EPC STORMWATER REVIEW COMMENTS  
IN ORANGE BOXES WITH BLACK TEXT

LOT 1 WOODMEN HILLS  
FILING NO 7H  
PRELIMINARY GRADING PLAN

PCD FILE NO. PPR2049

**LOT 1 WOODMEN HILLS FILING NO 7H GRADING & EROSION CONTROL PLAN**

PCD FILE NO. PPR-20-049

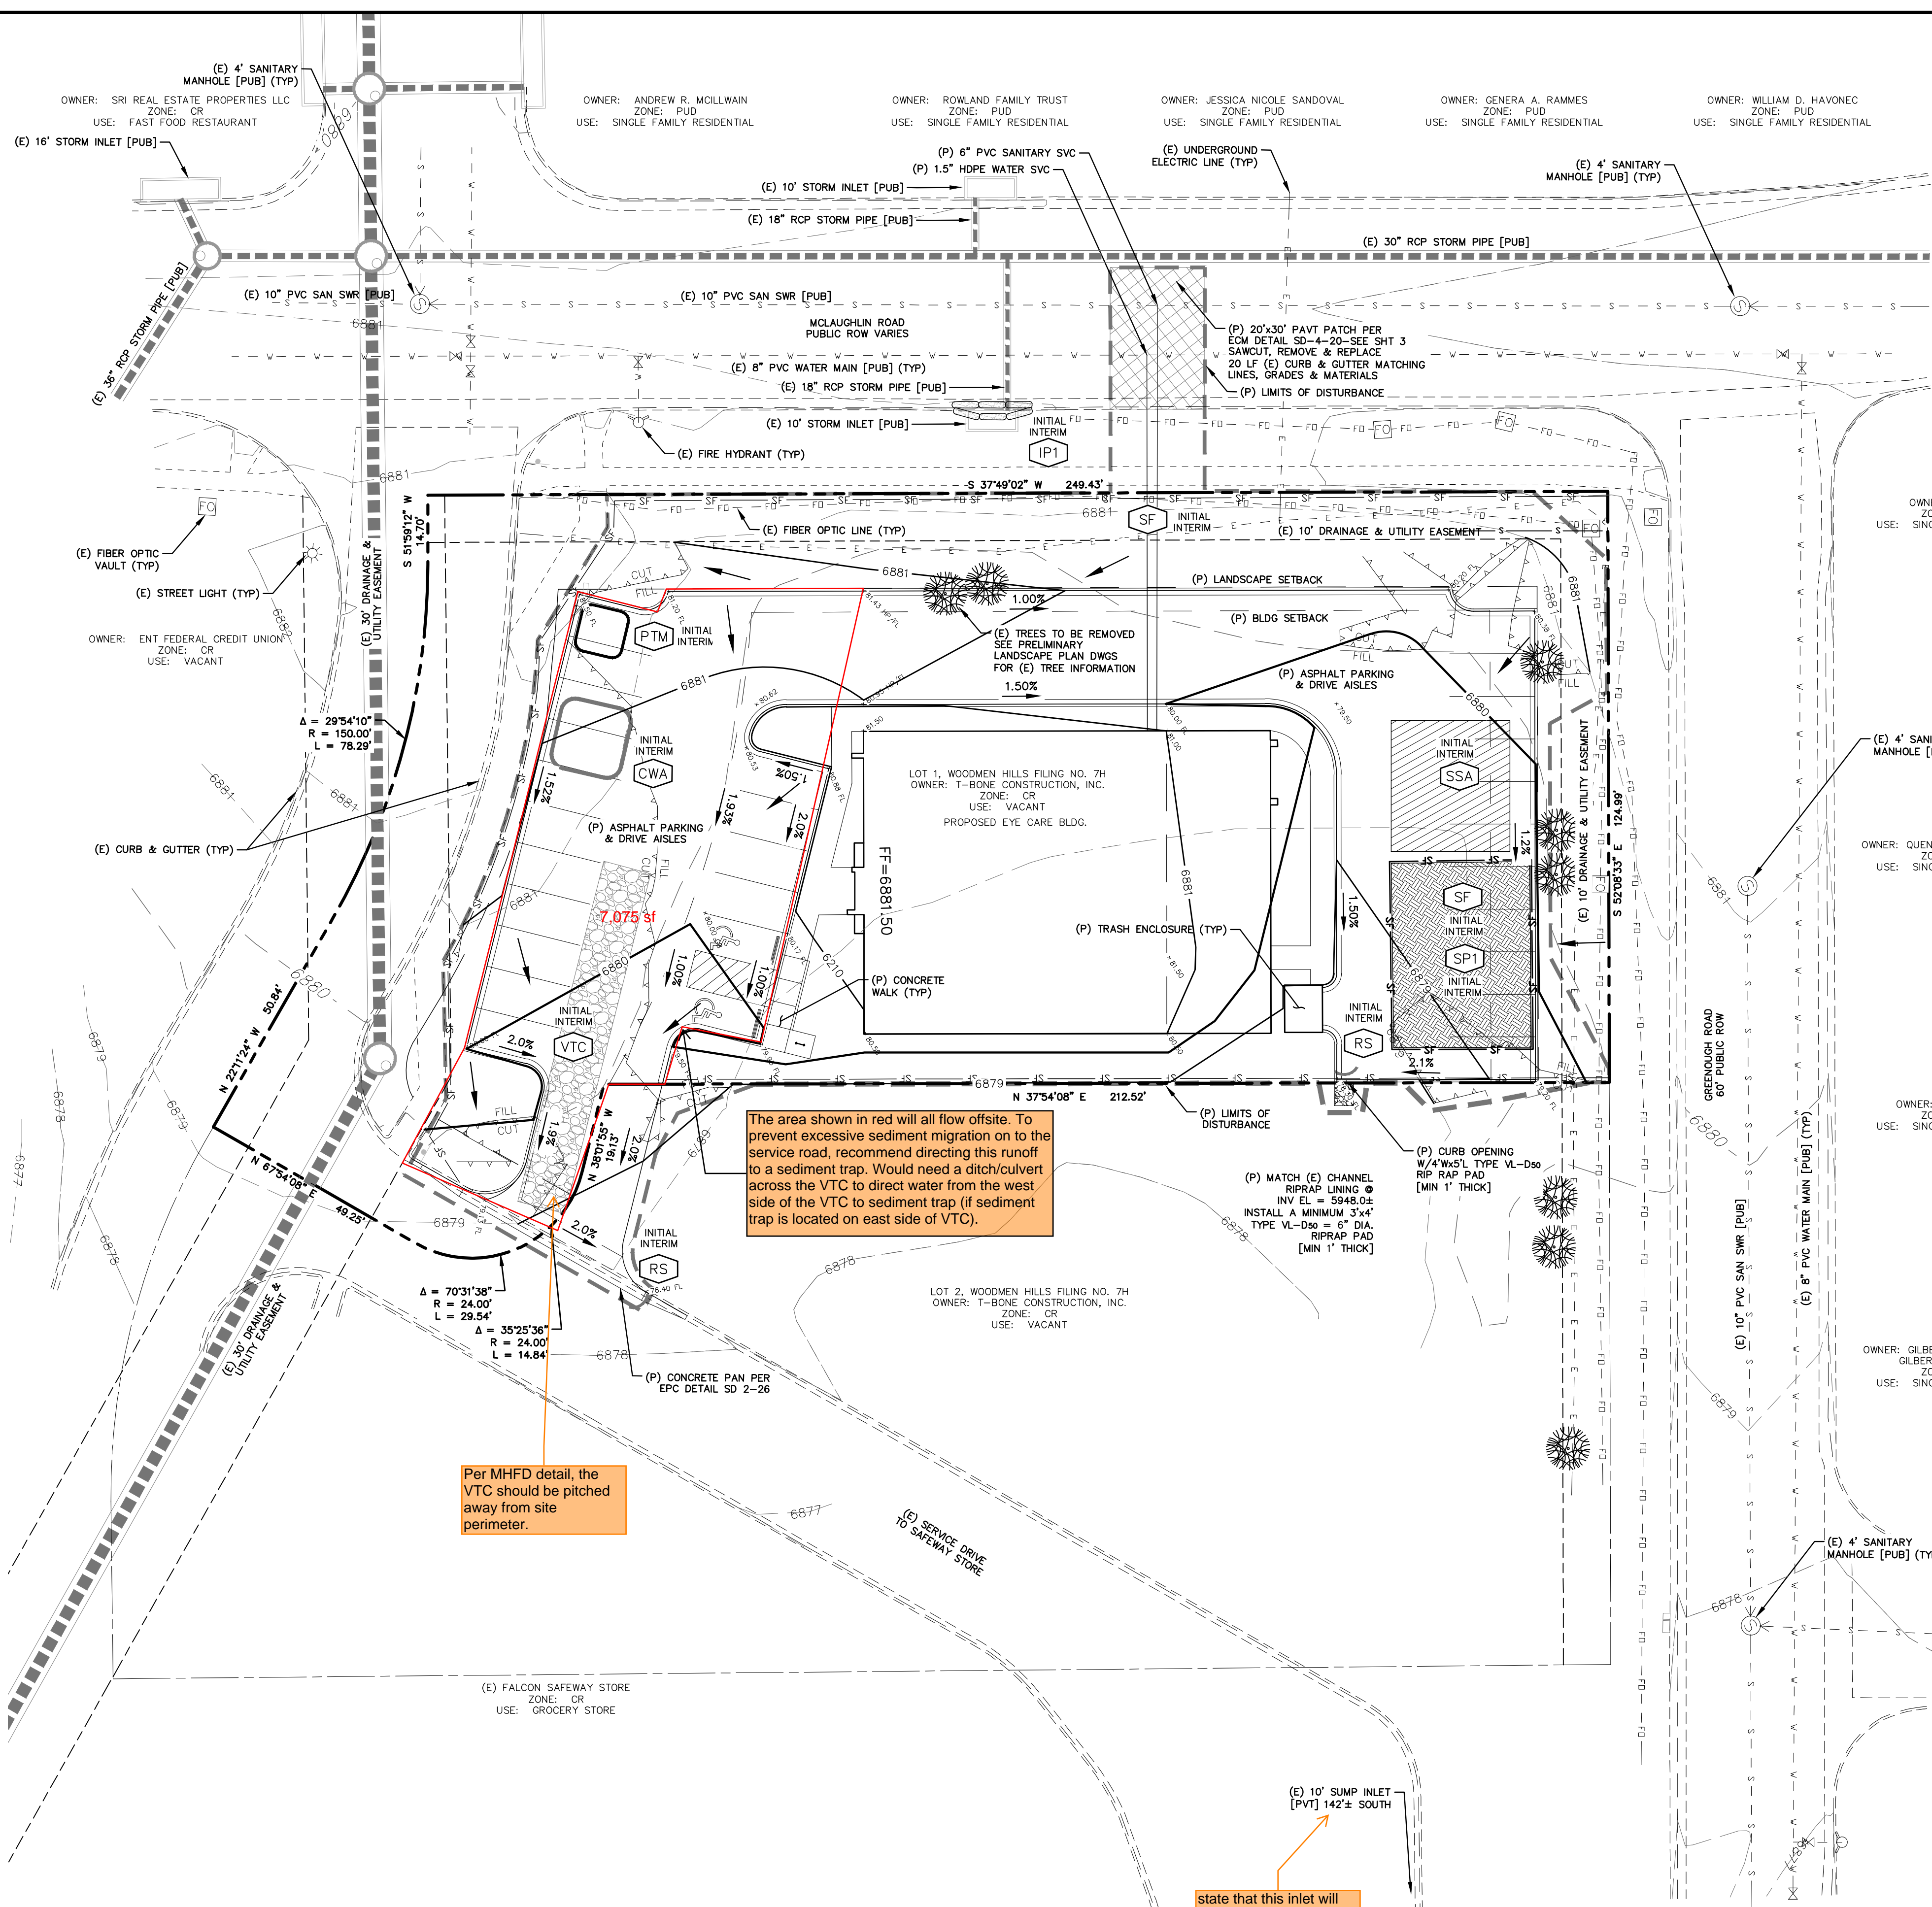
**GEC Checklist Item i - Include a note about the condition of the existing vegetation, similar to what is on page 3 of 14 of the drainage letter.**
